KIRKLEES METROPOLITAN COUNCIL INVESTMENT & REGENERATION SERVICE

DELEGATED DECISION TO DETERMINE APPLICATIONS FOR CONSENT, AGREEMENT OR APPROVAL REQUIRED BY CONDITION

Reference No: 2018/44/90491/W

Site Address: 120 Laund Road, Salendine Nook, Huddersfield, HD3 3TY

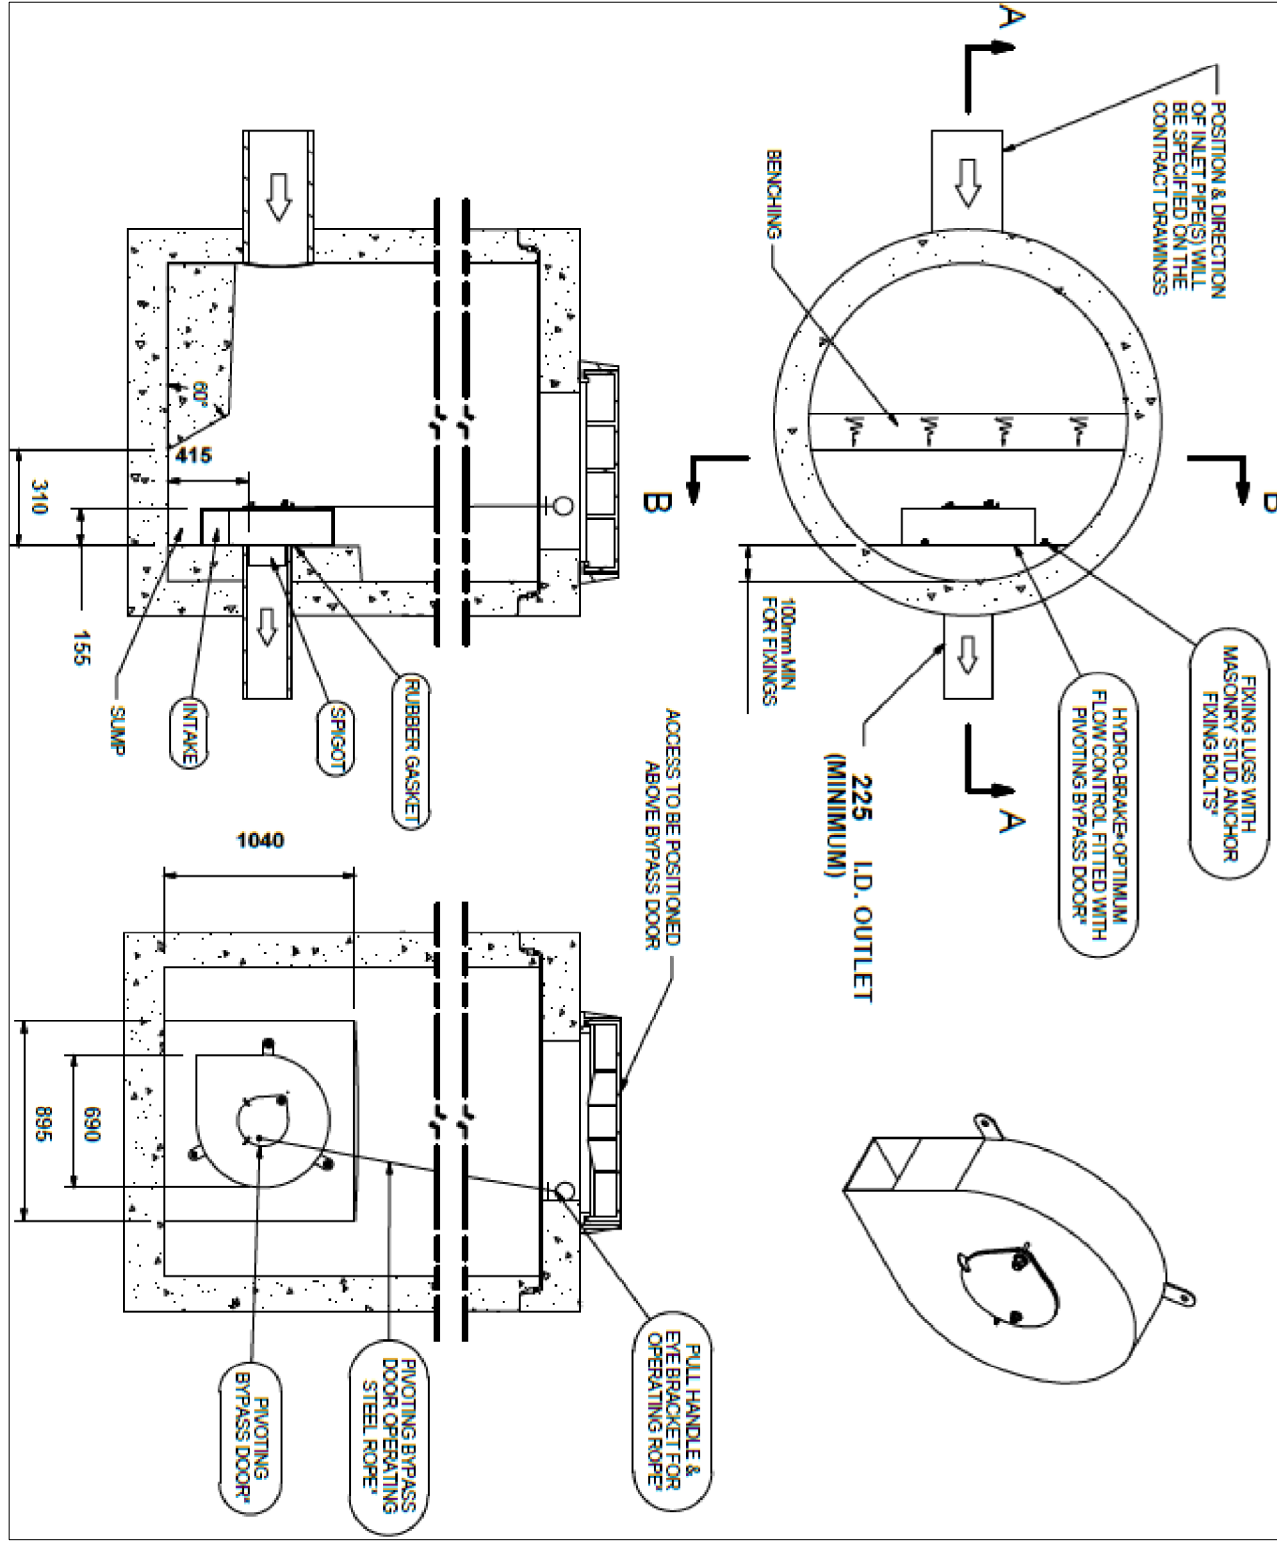
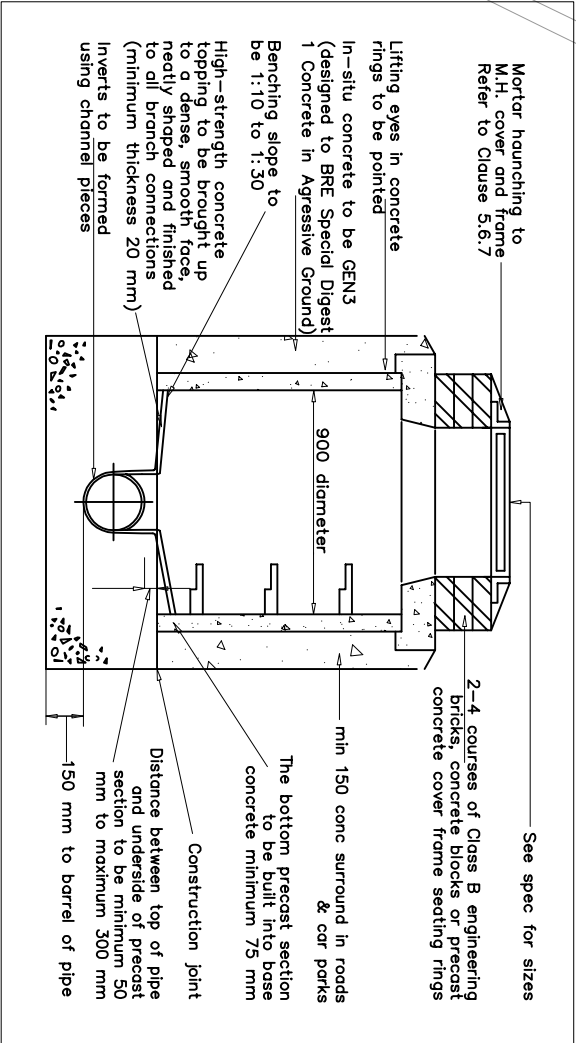
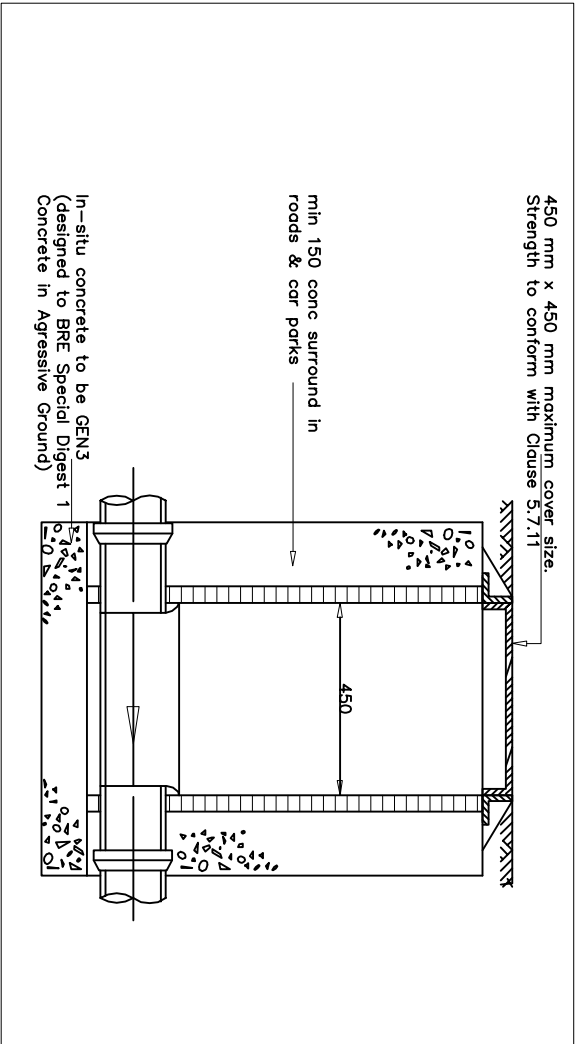
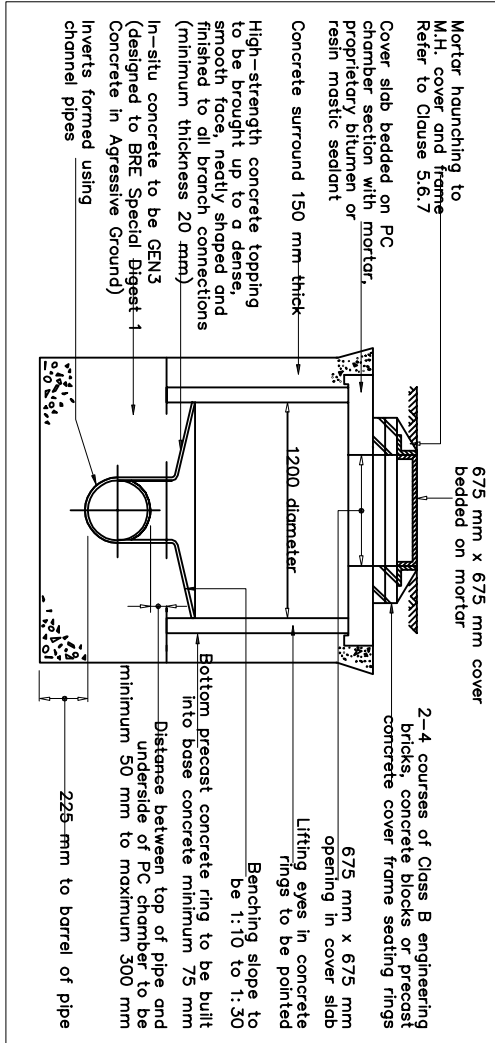
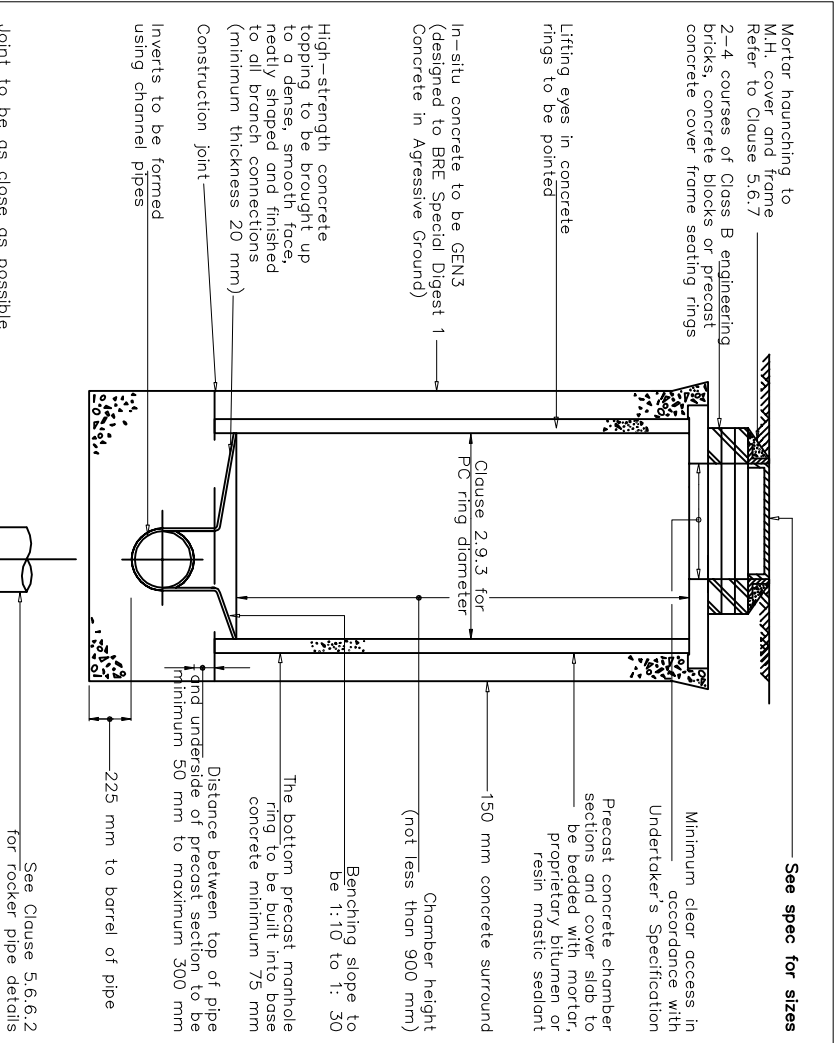
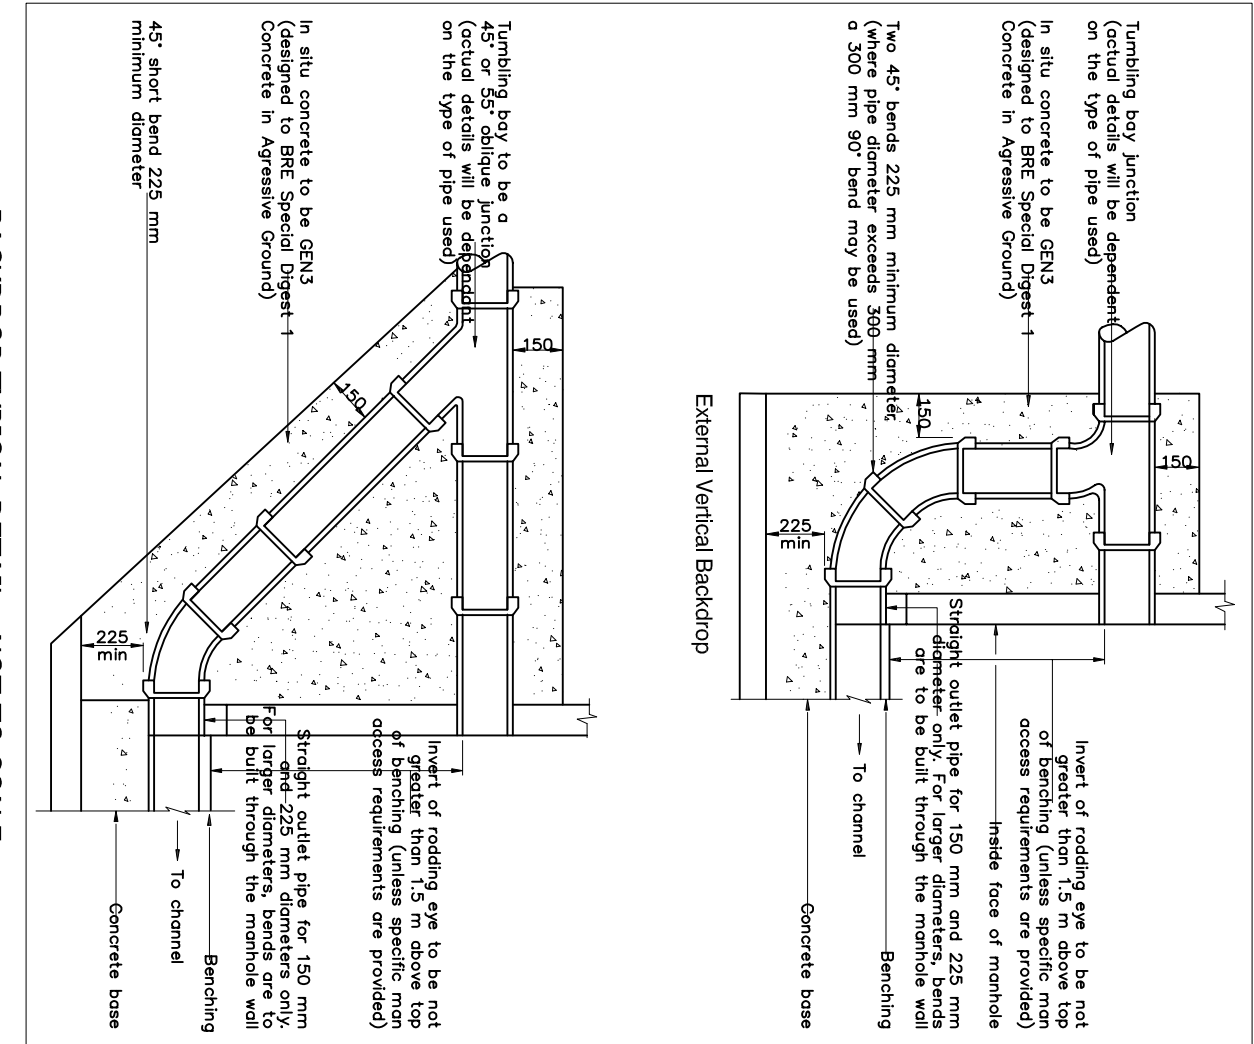
On 27/03/2018 the Lead Local Flood Authority (LLFA) noted that the proposed design far exceeded the 3l/s minimum required by condition 5, raised other concerns regarding the applicant's submission, and advised that conditions 4 and 5 should not be discharged.

On 11/04/2018 Yorkshire Water (YW) advised that the submitted details were not acceptable. YW requested evidence to show that other means of surface water disposal (other than discharge to the public sewer) have been considered, and to explain why any other methods have been discounted. YW also requested evidence of existing impermeable areas positively draining to the public sewer.

On 02/10/2018 and 16/10/2018 the applicant submitted an amended drawing titled Drainage Plan & Details (rev p2) and a Detailed Drainage Design document (T J Booth Associates, dated 23/03/2018). These showed 1800mm attenuation pipes beneath the development's new estate road and a hydro brake, and referred to a 5l/s discharge rate to the YW sewer.

Also on 30/10/2018, the LLFA noted that the applicant appeared to have permission from YW for a 5l/s discharge rate, and that the LLFA would not contest this. The LLFA also confirmed that the proposed tank size (on-site attenuation) was adequate. The LLFA noted, however, that with the proposed 1800mm pipes, the new estate road would not be adoptable. On 30/11/2018 the LLFA confirmed that conditions 4 and 5 could be discharged, provided that it is emphasised to the applicant that the new estate road could not be adopted.

Condition 4 – Drawing titled Drainage Plan & Details (rev p2) received on 02/10/2018 and information set out in the Detailed Drainage Design document (T J Booth Associates, dated 23/03/2018) received on 16/10/2018 are considered acceptable for the purpose of condition 4. Condition 4 will be discharged upon completion of the drainage works in accordance with these details.

Condition 5 – Although the applicant has submitted proposals for a higher discharge rate than the 3l/s rate specified in condition 5, drawing titled Drainage Plan & Details (rev p2) received on 02/10/2018 and information set out in the Detailed Drainage Design document (T J Booth Associates, dated 23/03/2018) received on 16/10/2018 are considered acceptable for the purpose of condition 5. Condition 5 will be discharged upon completion of the drainage works in accordance with these details. Please note that the inclusion of 1800mm diameter pipes in the drainage works precludes the adoption of the development's internal roads.

120 LAUND ROAD, SALENDINE NOOK		DRAWN BY MB
SECTION 38 DESIGN AND LONG SECTION		CHECKED BY AH

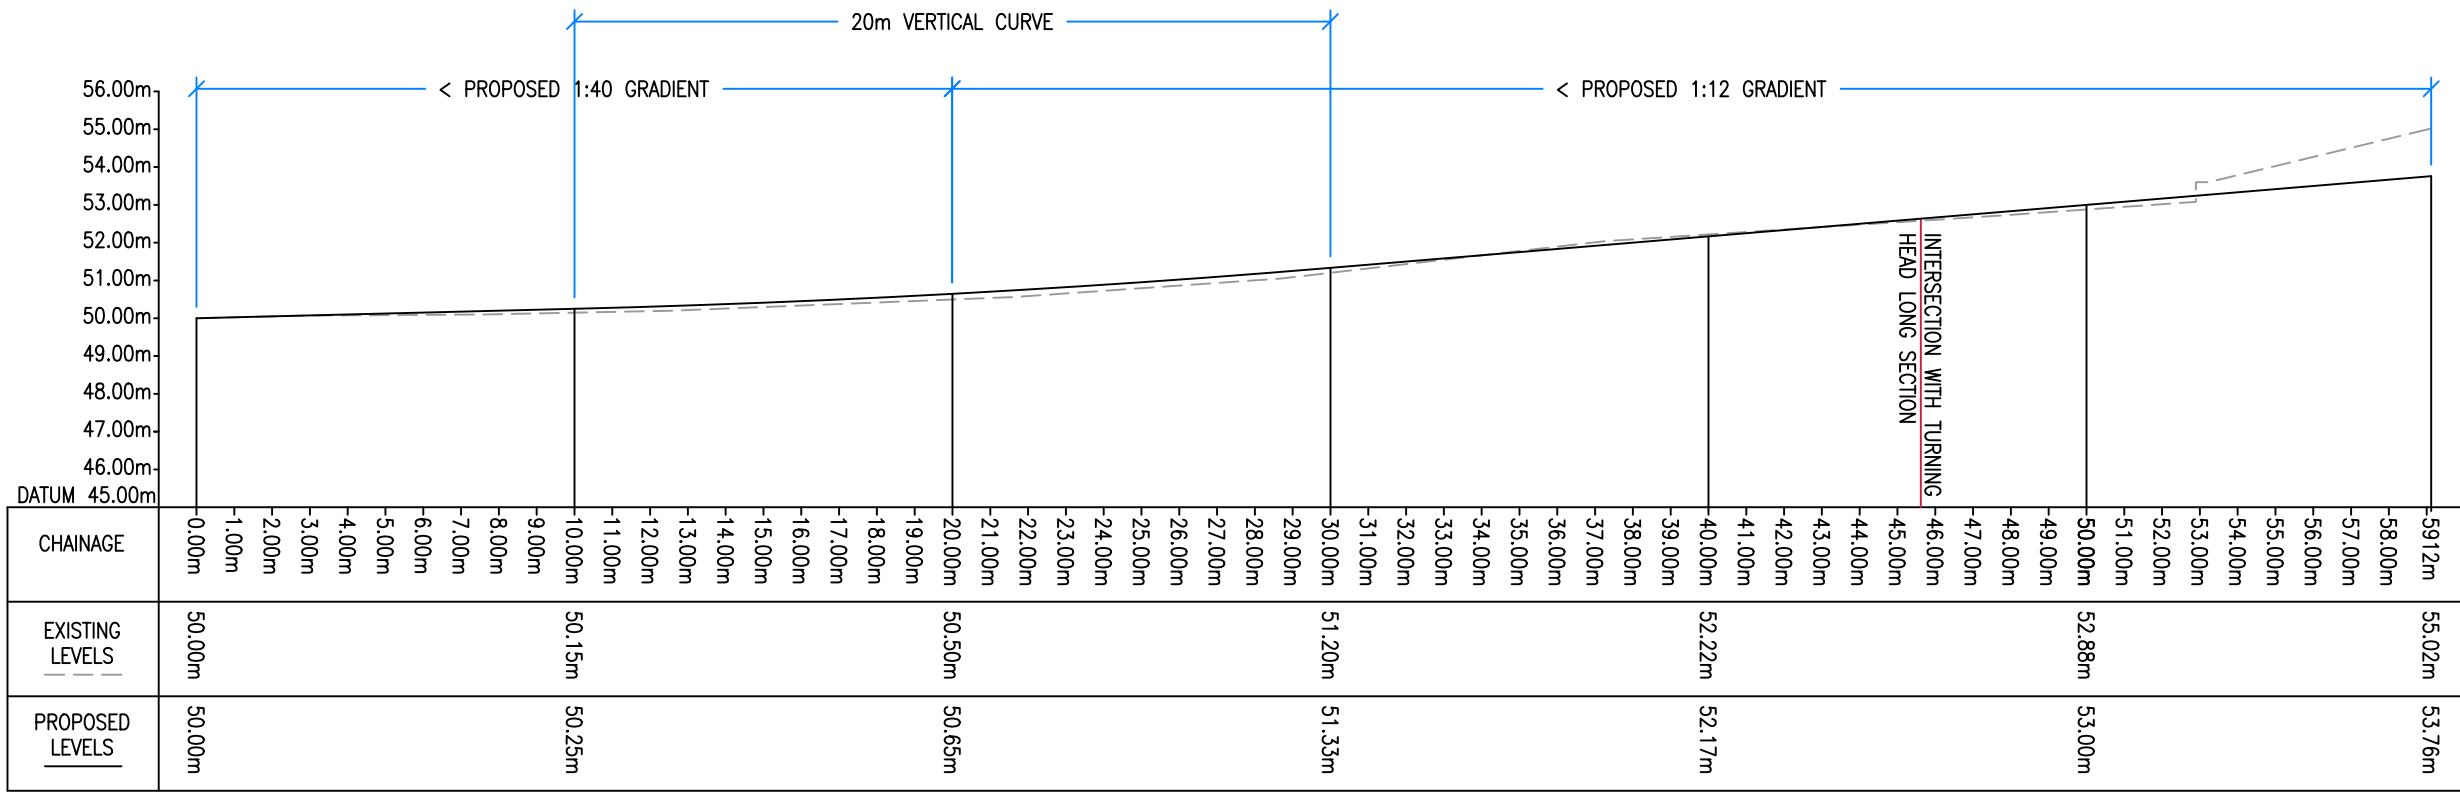
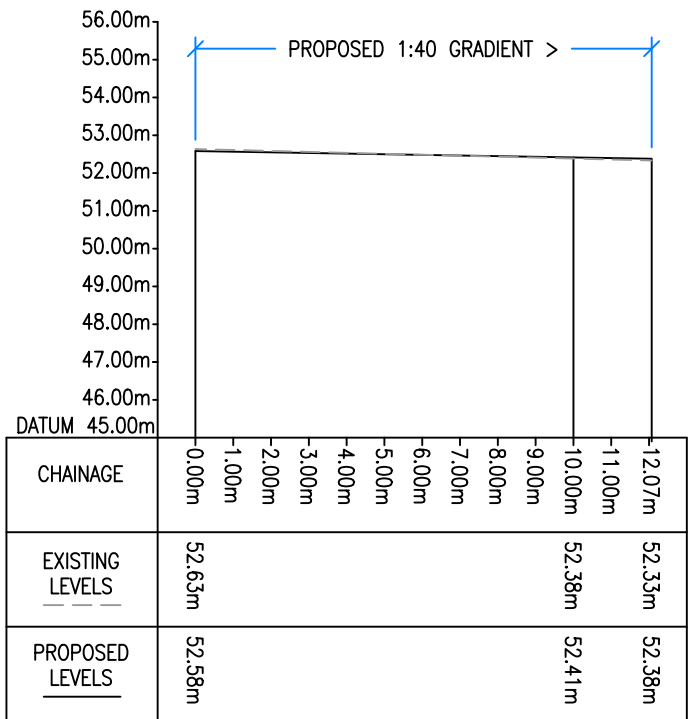
The above information details the junction of the development's new estate road and Laund Road, including 2.4m x 43m visibility splays.

HDM officers visited the site in November 2018 to ascertain whether adequate sight lines had been, or could be, provided at the junction of the development's new estate road and Laund Road. In comments dated 30/11/2018, HDM officers advised that condition 8 can be discharged.

Condition 8 – Drawings 101 (Section 38 Design and Long Section) and 102 (Cross Sections), and information set out in the Road Safety Audit and Designers Response (both Paragon Highways, ref: 1387, dated May 2018, received 04/07/2018) are considered acceptable for the purpose of condition 8. Condition 8 will be discharged upon completion of the development in accordance with these details.

Condition 10 – Drawings 101 (Section 38 Design and Long Section) and 102 (Cross Sections), and information set out in the Road Safety Audit and Designers Response (both Paragon Highways, ref: 1387, dated May 2018, received 04/07/2018) are considered acceptable for the purpose of condition 10. Condition 10 will be discharged upon completion of the development in accordance with these details. Please note that the development's internal roads will not be adopted by the council.
